WEST SUSSEX COUNTY COUNCIL CONSULTATION

TO:	Arun District Council FAO: Maria Tomalova
FROM:	WSCC - Highways Authority
DATE:	26 May 2022
LOCATION:	Oak Bank, Wandleys Lane, Walberton, BN18 0QR
SUBJECT:	WA/50/22/PL 1 No 4 bed dwelling with detached garage and associated parking (resubmission following WA/8/22/PL). This application is a Departure from the Development Plan and is in CIL Zone 3 and is CIL Liable as a new dwelling.
DATE OF SITE VISIT:	N/A
RECOMMENDATION:	Advice
S106 CONTRIBUTION TOTAL:	N/A

Site Block Plan 1:200

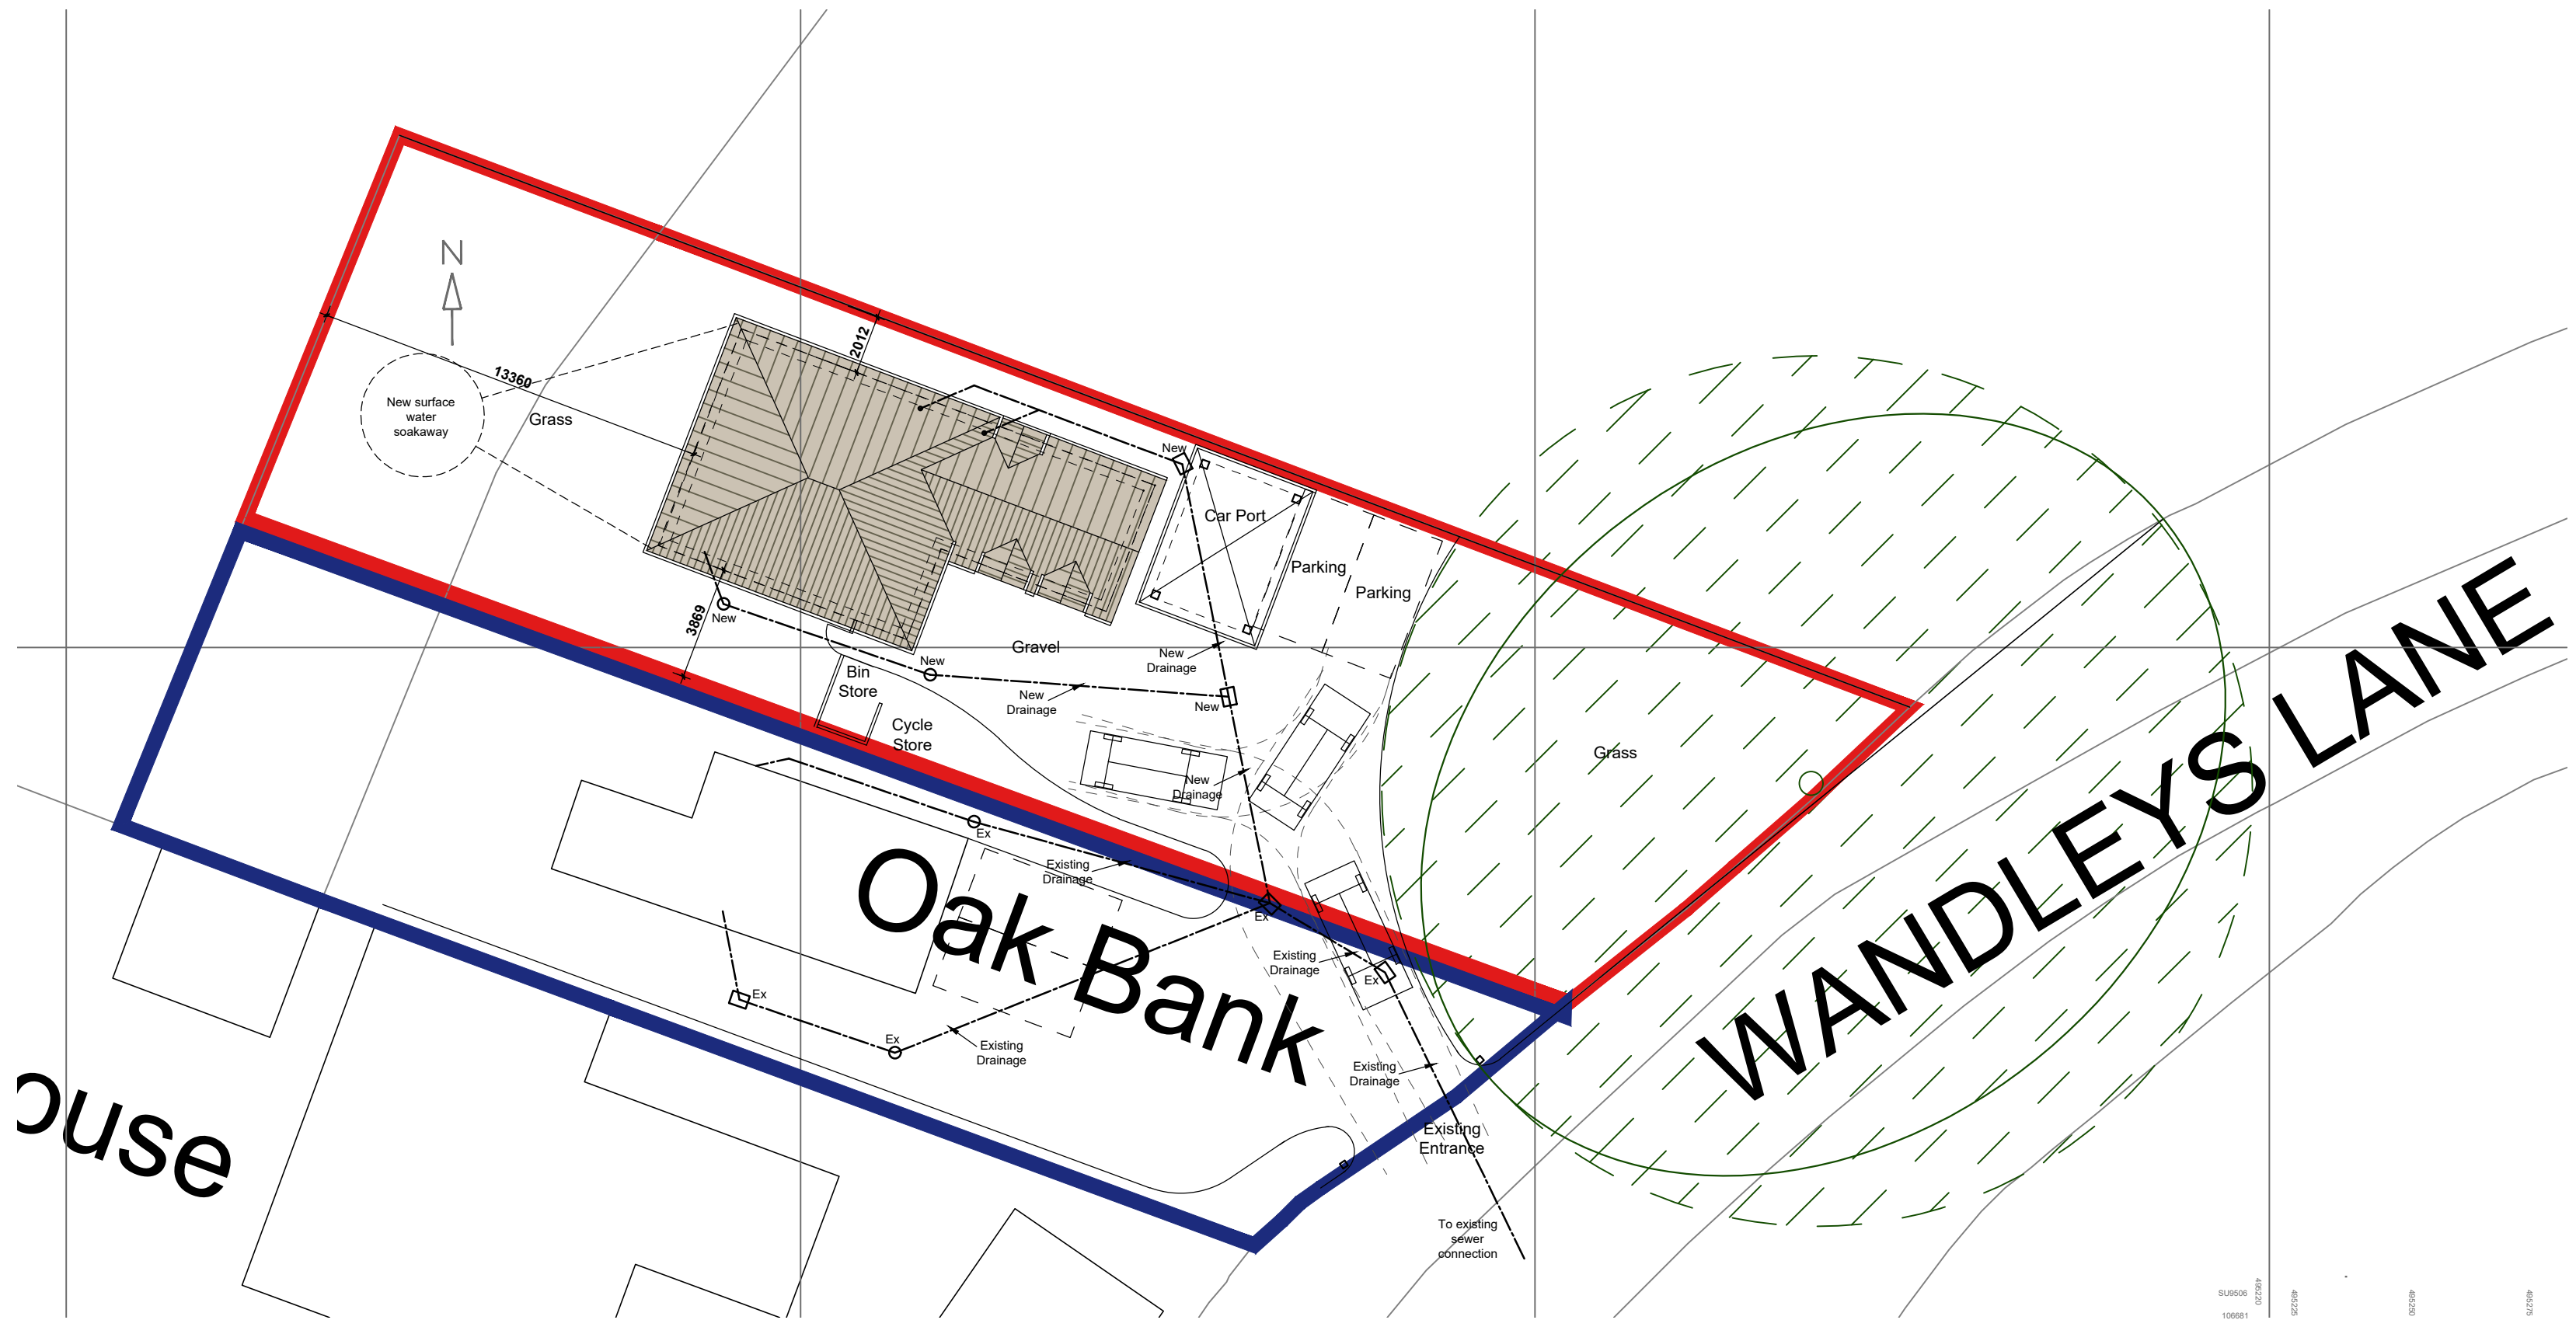
The applicant proposes to utilise the existing access on Wandleys Lane, forming a shared access point. From inspection of the plans and WSCC mapping, there are no apparent visibility concerns with the existing point of access on to the maintained highway. In addition, the LHA does not anticipate that the addition of one dwelling would give rise to a significant material intensification of movements to or from the site.

The applicant proposes three car parking spaces, comprising a single carport and two parking bays. Under Arun Parking Standards, the LHA would expect a parking provision for at least three parking spaces for a dwelling of this size in this location. Therefore, the LHA considers the proposed parking provision to be sufficient. The applicant has also demonstrated that on-site turning is achievable, allowing cars to exit the site in a forward gear.

Regarding cycles, the applicant has demonstrated the location of a proposed cycle store. The applicant should provide secure and cycle parking provision in accordance with Arun Parking Standards.

No part of the development shall be first occupied until the car parking has been constructed in accordance with the approved site plan. These spaces shall thereafter be retained at all times for their designated purpose.

No part of the development shall be first occupied until covered and secure cycle parking spaces have been provided in accordance with plans and details to be submitted to and approved by the Local Planning Authority.

No part of the development shall be first occupied until the electric vehicle charging space(s) have been provided in accordance with plans and details to be submitted to and approved by the Local Planning Authority.
